Application No: EP/35/22/HH
Site Address: West House South Strand East Preston BN16 1PN
Description of works: Erection of single storey front extension, first floor front/side extension and alterations to fenestration/openings.

This council's Planning & Licensing Committee considered this Application at its meeting on 25th April. The applicants were invited to attend but did not do so.

N ELEV

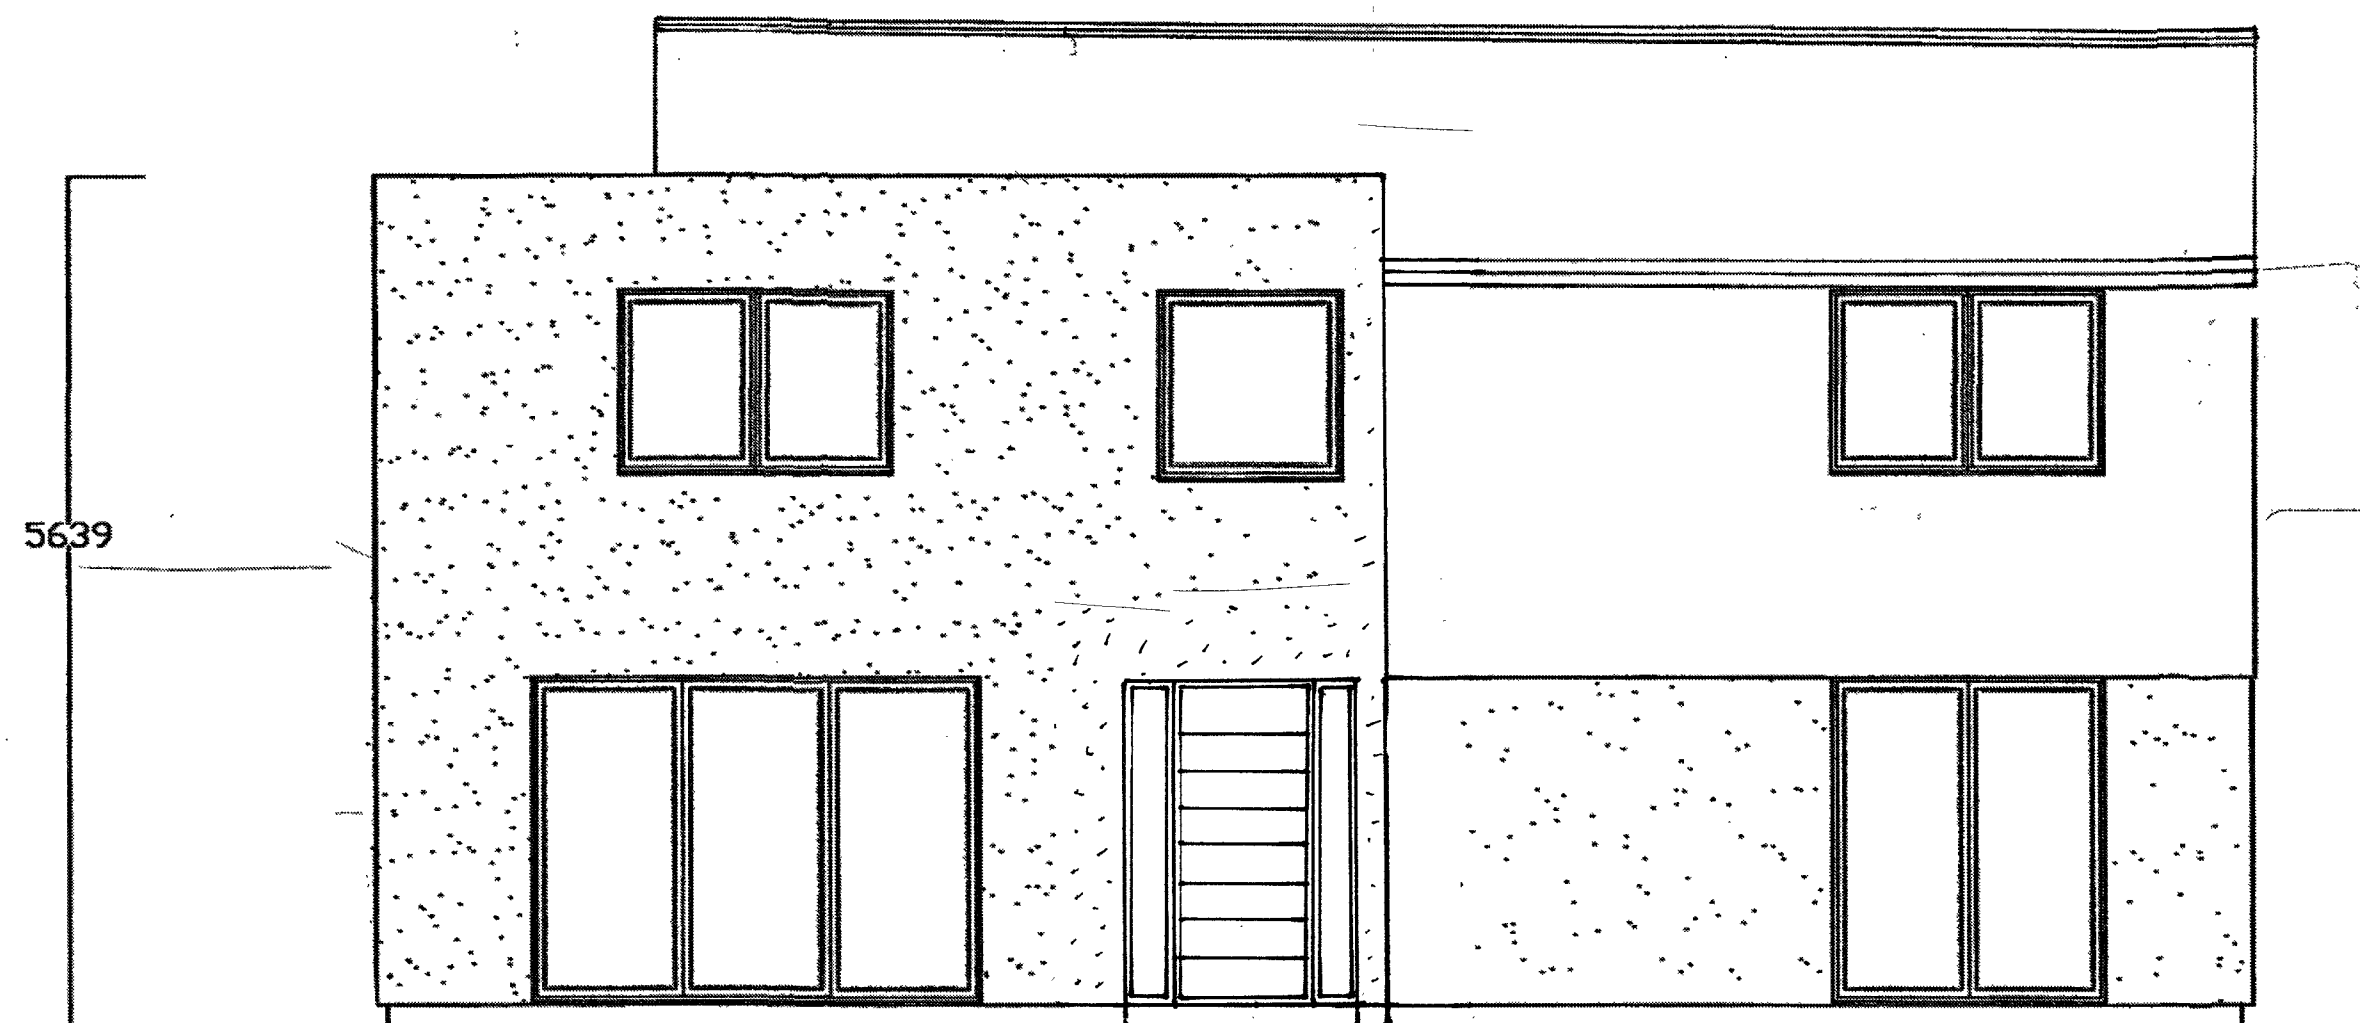
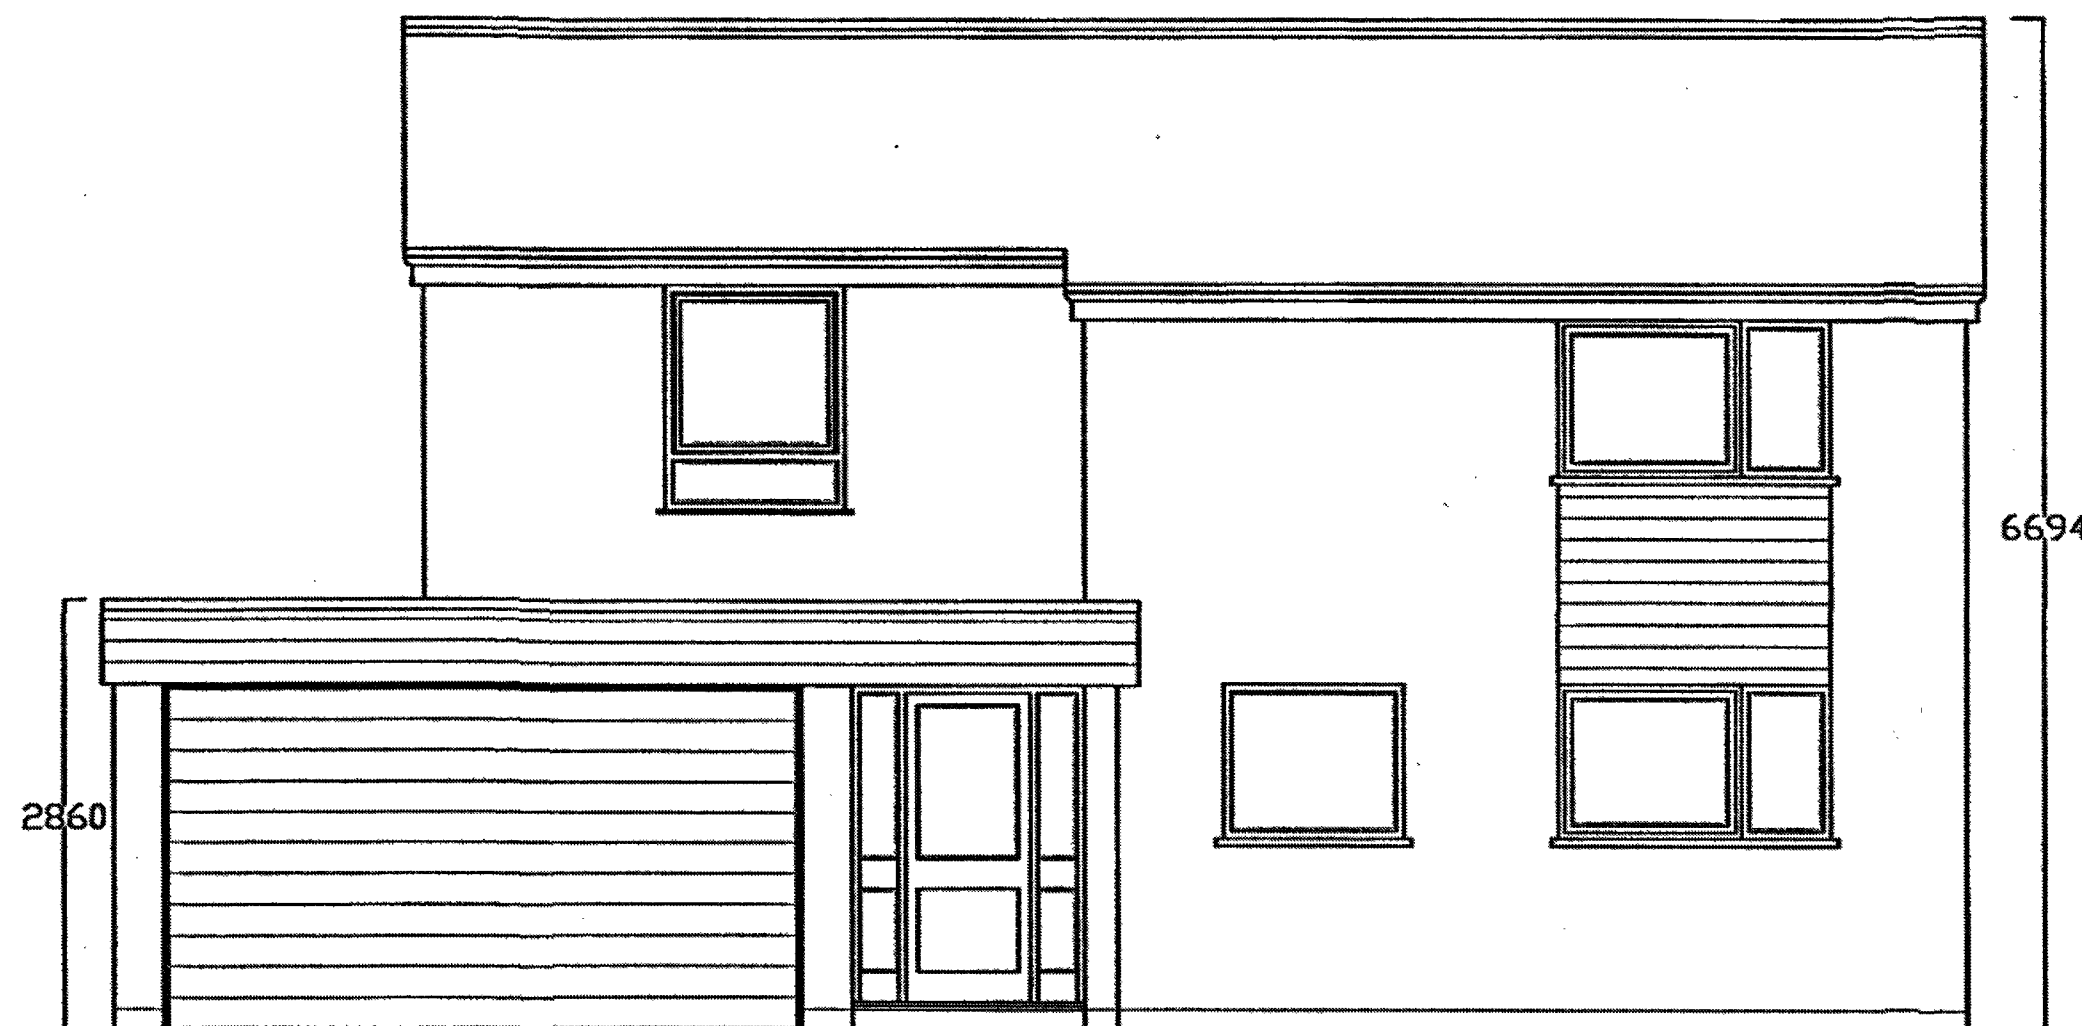
The committee remained concerned the proposed first-floor extension is not well integrated into the existing building. This will be very visible from the north and could be deemed to change the streetscene in South Strand. This extension may also be overbearing towards the property to the east of the application site.
